**Addendum No. 1**

RE: Contract # C203833

US-1 From SR-1731 To Moore County Line, US-1 From Crains Creek To Crystal Lake Road and 6 Sections of Secondary Roads

**March 15, 2016 Letting**

PROJECT NO.	SHEET NO.	TOTAL NO.
2016CPT.08.10.10531, etc	10

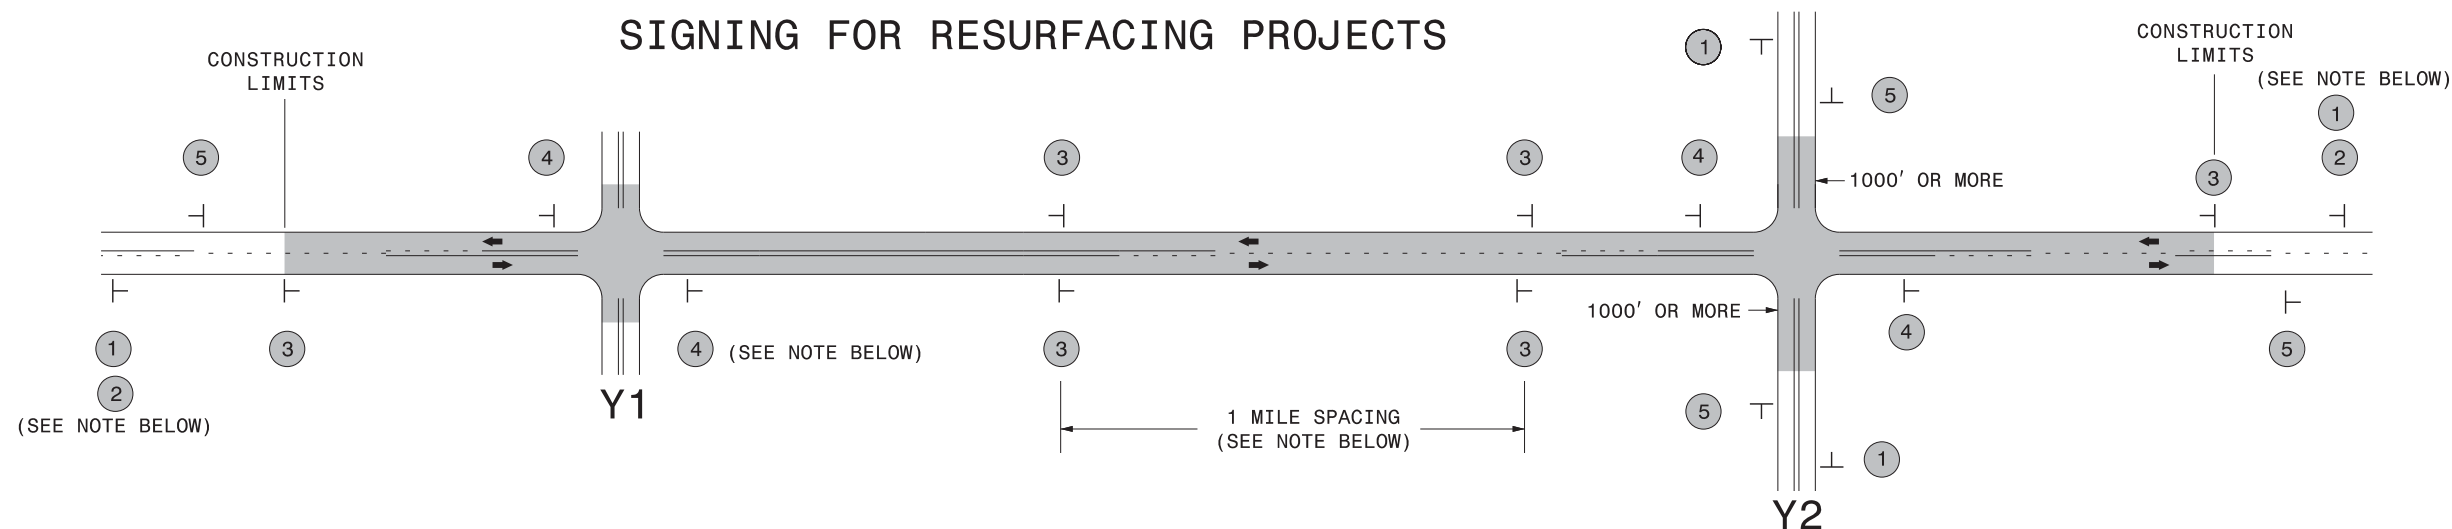
Sheet No.	Revisions
10	No changes to this sheet other than to move the pavement markings to New sheet No. 11
11(New)	Revised to reflect the below noted quantity change and pay item additions

Please void Sheet No. 10 in your plans and staple the revised Sheet No. 10 and New Sheet No. 11 thereto.
